**Ministerial Correspondence Unit - Thomas St, Chatswood, car park development:MP09\_0066 Mod 6**

**Thomas Street Car park site, Chatswood | MP09\_0066 Mod 6 | Response to amended plans**

As Secretary of the Executive Committee of the Owners' Corporation of 12 Thomas Street, Chatswood I am responding to the amended plans for Modification 6 for the above named development. My objections are as follows:

BUILDING 1
ELEVATION - EAST
A-0123
D
SECTION 75 W MODIFICATION 6

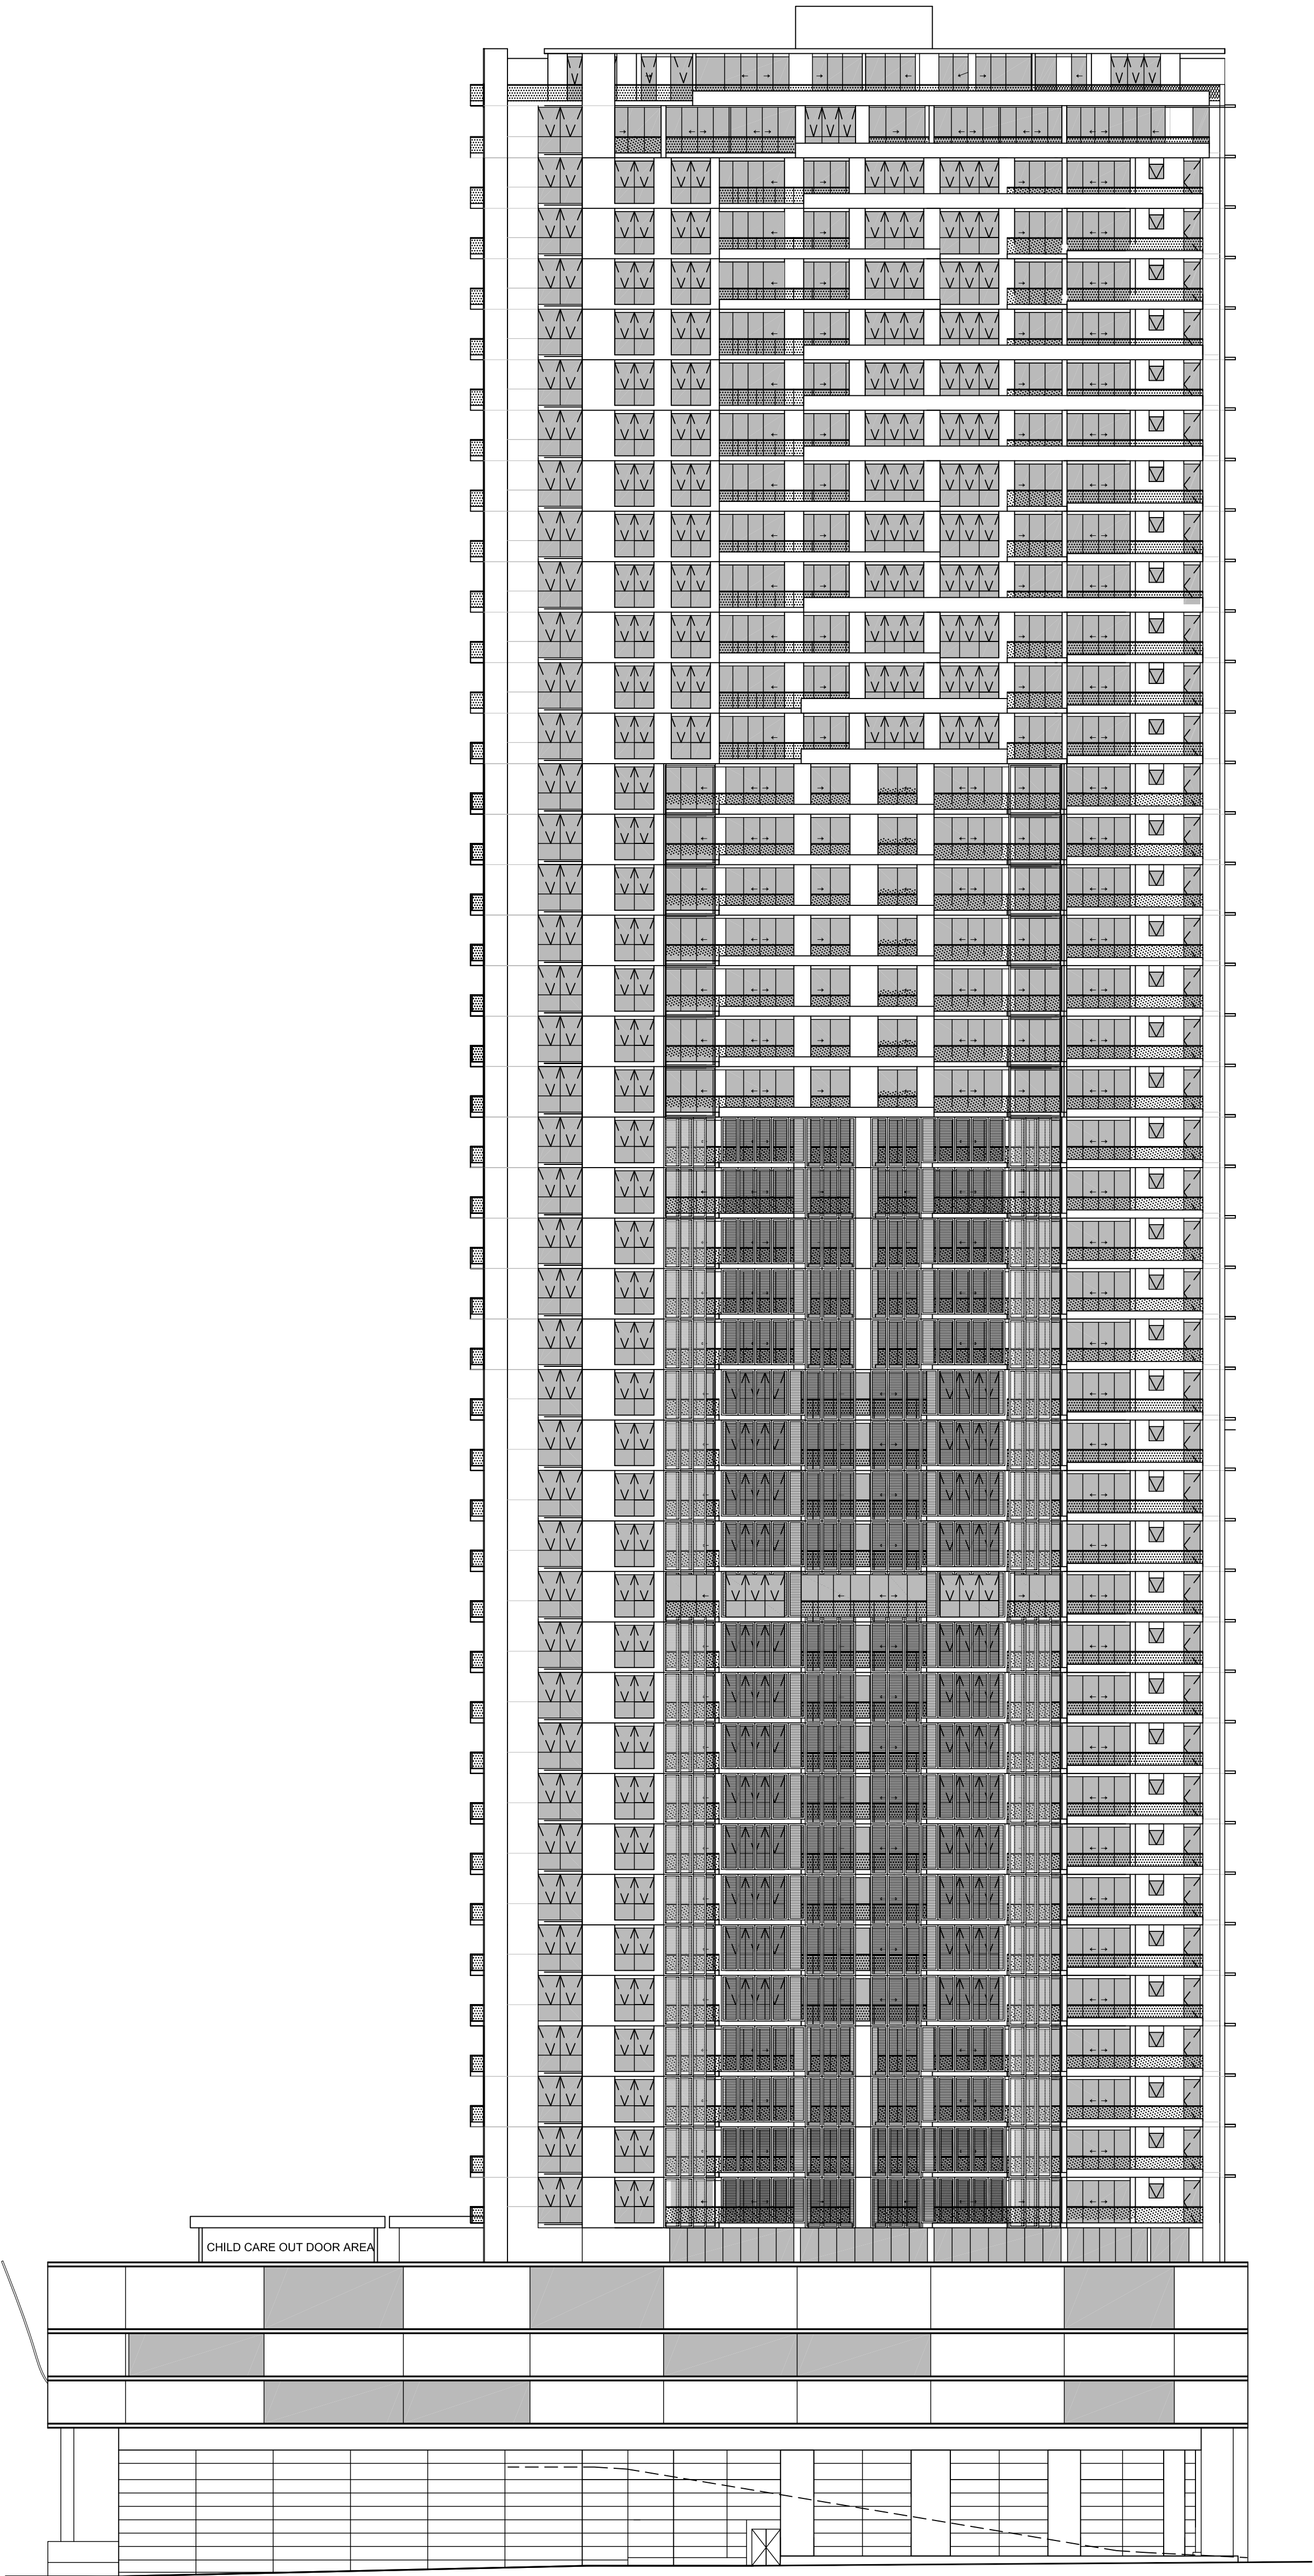
the boundary of 12 Thomas Street. Modification 6 introduces a nil setback podium impacting negatively on visual impacts for western facing offices in 12 Thomas Street.

- Modification 3 has a right of way approximately 4.2 metres wide which could be constructed in such a way as to safely accommodate pedestrians as well as vehicles. This would provide access to the ramp at the rear of 12 Thomas Street for mothers with strollers, those with mobility issues, the visually impaired, the elderly, the disabled and others who cannot negotiate steps. It would also allow connectivity between Thomas Street and Fleet Lane which has been lost with the sale and subsequent closure of the Thomas Street car park and part of Fleet Lane. Modification 6 provides only a 3 metre wide right of way that would be used by service vehicles accessing the loading dock.
